Planning Application Ref: P/70/19/RES

Location: Land North of Summer Lane, Pagham, PO21 4NG

Description of works: Approval of reserved matters following outline consent P/58/15/OUT for 90 No. dwellings. Also seeking to address the terms of planning conditions 6 (Phasing), 8 (ecology), 9 (Surface Water), 12 (Vehicular Access), 15 (Parking), 18 (Travel Plan), 20 (Landscape Management), 24 (Parking Control), 25 (Dwelling Parking) and 26 (Materials)

Mark Warwick
Tree Officer / Parks and Greenspace Team

Client	Drew Smith Group		
Project	Summer Lane, Pagham West Sussex		
Drawing Title	Tree Survey		
Scale	Date	DB	CB
1:500@A2	Jul 2019	MW	
Drawing Number	MW.19.0612.TS		Rev
			-

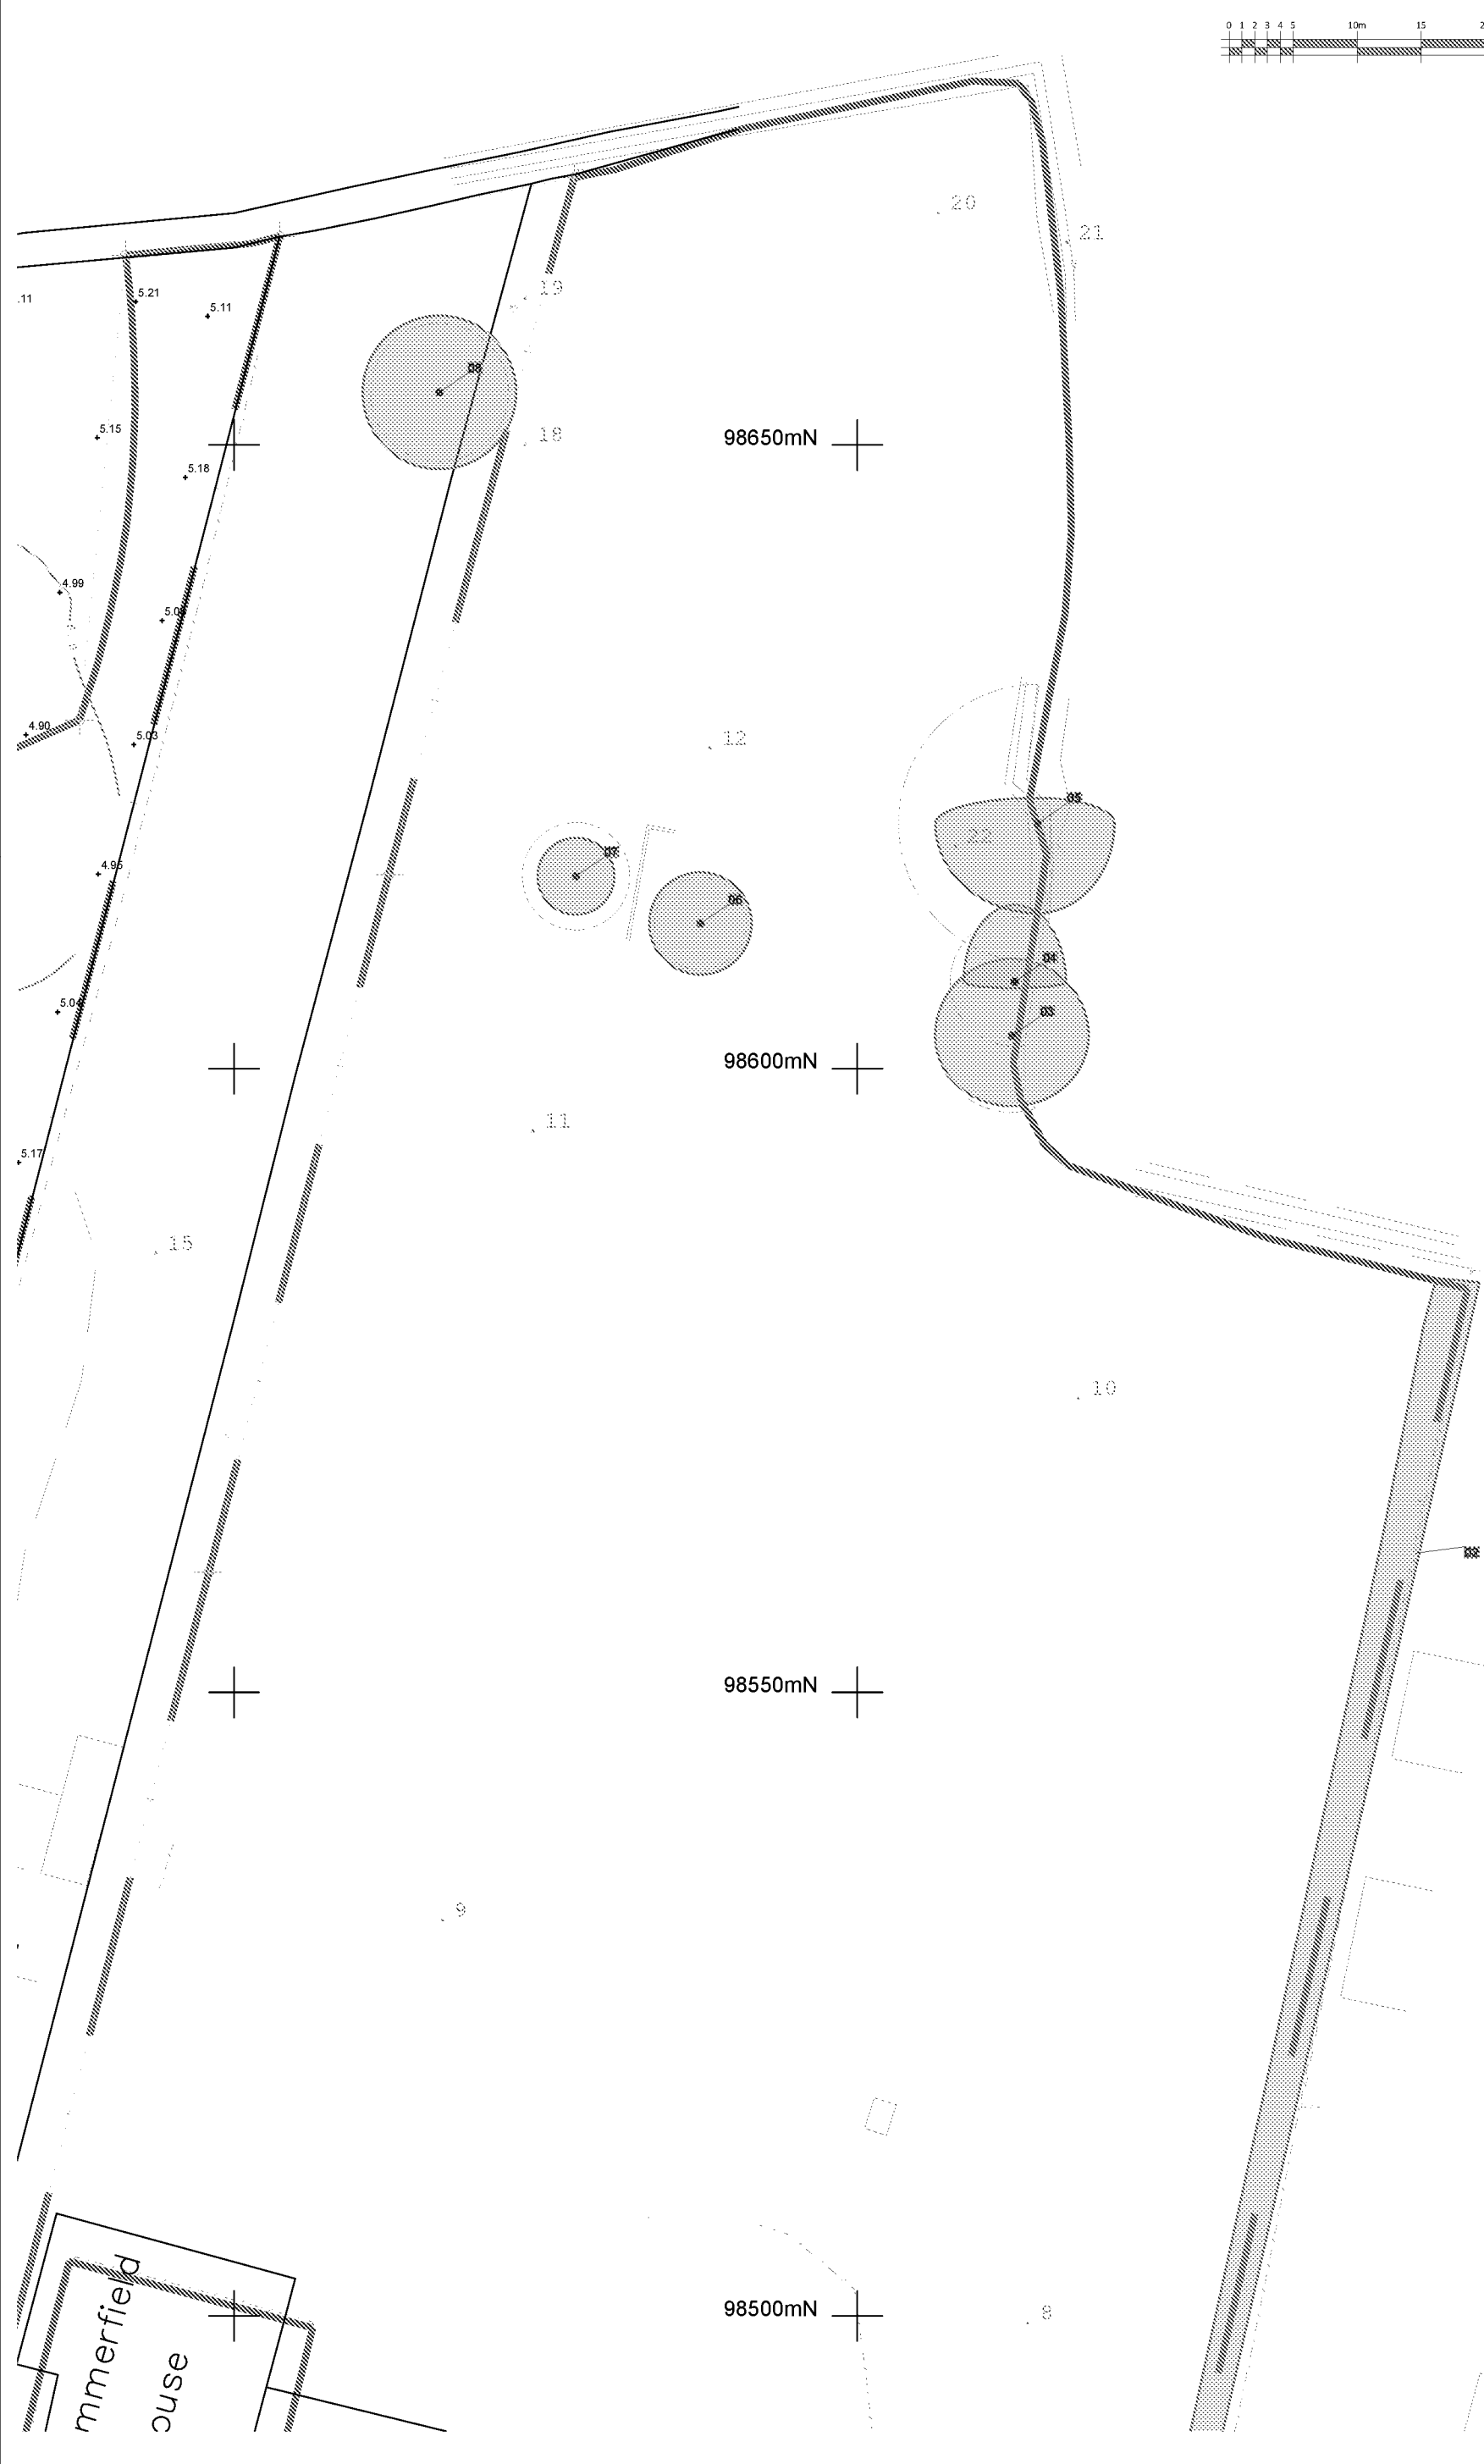
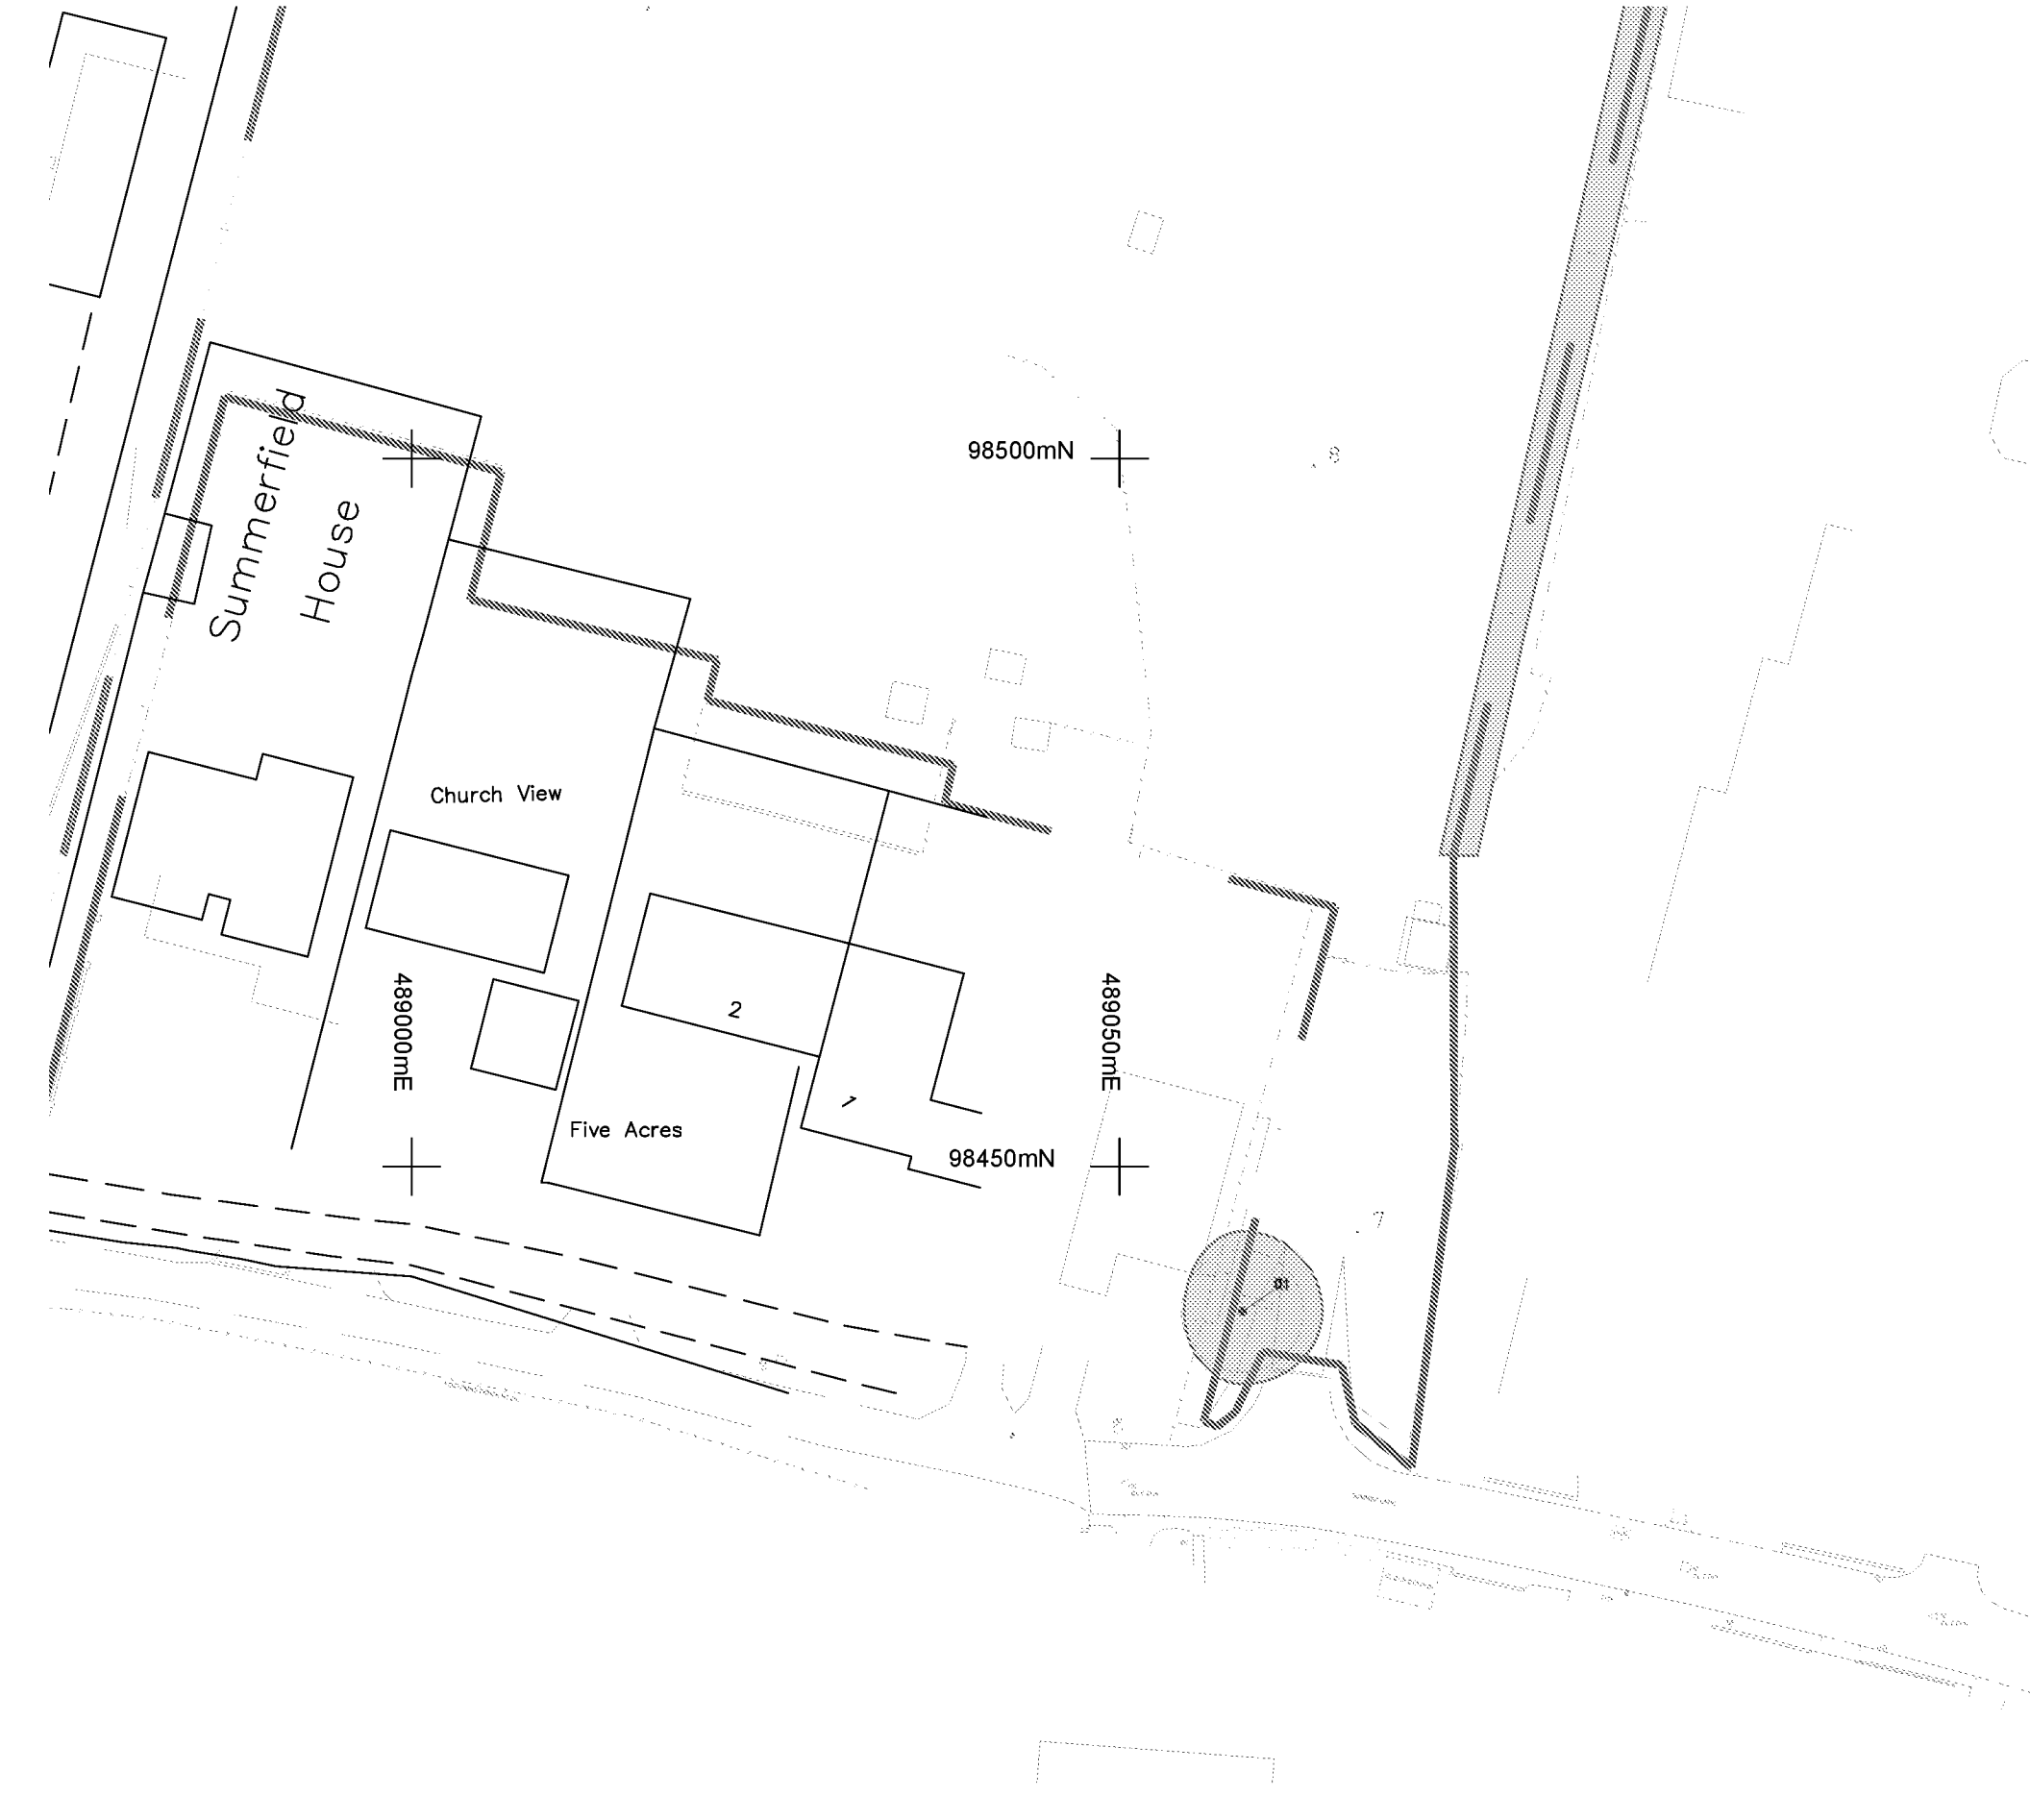
- The Tree Survey data is comprehensive and accords with the requirements of BS5837:2012, although I disagree with retention category ratings for the most significant of on-site trees (T03 and T05).

- The oaks T03 and T05 should not be confined within the development, rather they should be visible from multiple aspects. I would expect the root protection area (RPA) plus a 2metre buffer zone to be an absolute minimum requirement for these neglected trees. Ideally, they should be incorporated into an area of open space and be so remote from any development such that they can project veteran status in the future without being irrevocably spoilt by risk mitigation pruning.

- As it stands, I must register an **OBJECTION** to this proposal.
- A revised layout will need to be supported by an **Arboricultural Method Statement Report** inclusive of a **Tree Protection Plan** defining which trees are to be retained and which trees are to be removed and how they would propose to protect the retained trees and improve ground conditions so as to facilitate recovery and extension of their root systems.
- I follow up on a previous recommendation for the making of a Tree Preservation Order in respect of two pedunculate oak (referred to as **T03** and **T05** in the applicant's tree survey schedule) to preserve their place in the landscape and better inform a revised layout. I attach TEMPO forms and GIS plan for this purpose. Please advise both myself and the applicant on the outcome of this specific recommendation.

DRAWING TITLE
Proposed Site Plan
90 Unit Scheme

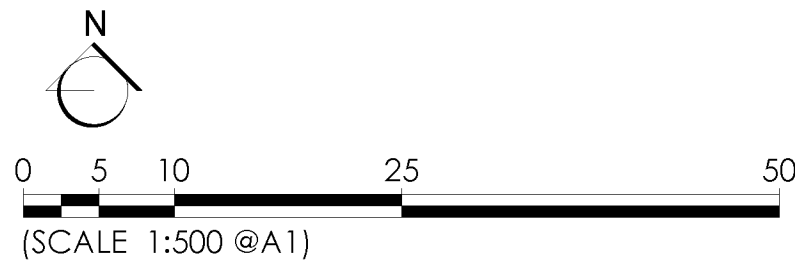
- The majority of proposed tree removals have either been approved already or are justified and acceptable.
- The current proposed layout assumes the removal of established oak trees which I assess as being of moderate value (Category B) in their current state and of potential landscape and high amenity value if adequately respected and protected from this point onwards. Their retention should be a major influence on any proposed site layout. They qualify and are suitable for, long-term preservation.

- As a general principle of design, careful consideration should be given to the intended land use beneath existing canopy of established trees and the potential for further growth (root and canopy expansion). With such a large and open site to work with I would expect a layout proposal to have placed great emphasis on utilising and enhancing the existing green infrastructure and eliminating future 'residential pressure to prune'.

- There would need to be a compelling argument in favour of any wholesale removal or incursion into the root protection area of mature trees, as this site clearly lends itself to a harmonious design that avoids any direct interference with such trees of current or potential landscape value. This becomes especially relevant where there are relatively few trees of such stature and quality, as is the case here.
- I find the extent of proposed tree loss unjustified and unacceptable. There is ample scope to revise the plot layout at the north-east corner of the site and successfully accommodate significant trees (oak T03 and T05) in long-term harmony with surrounding built form.
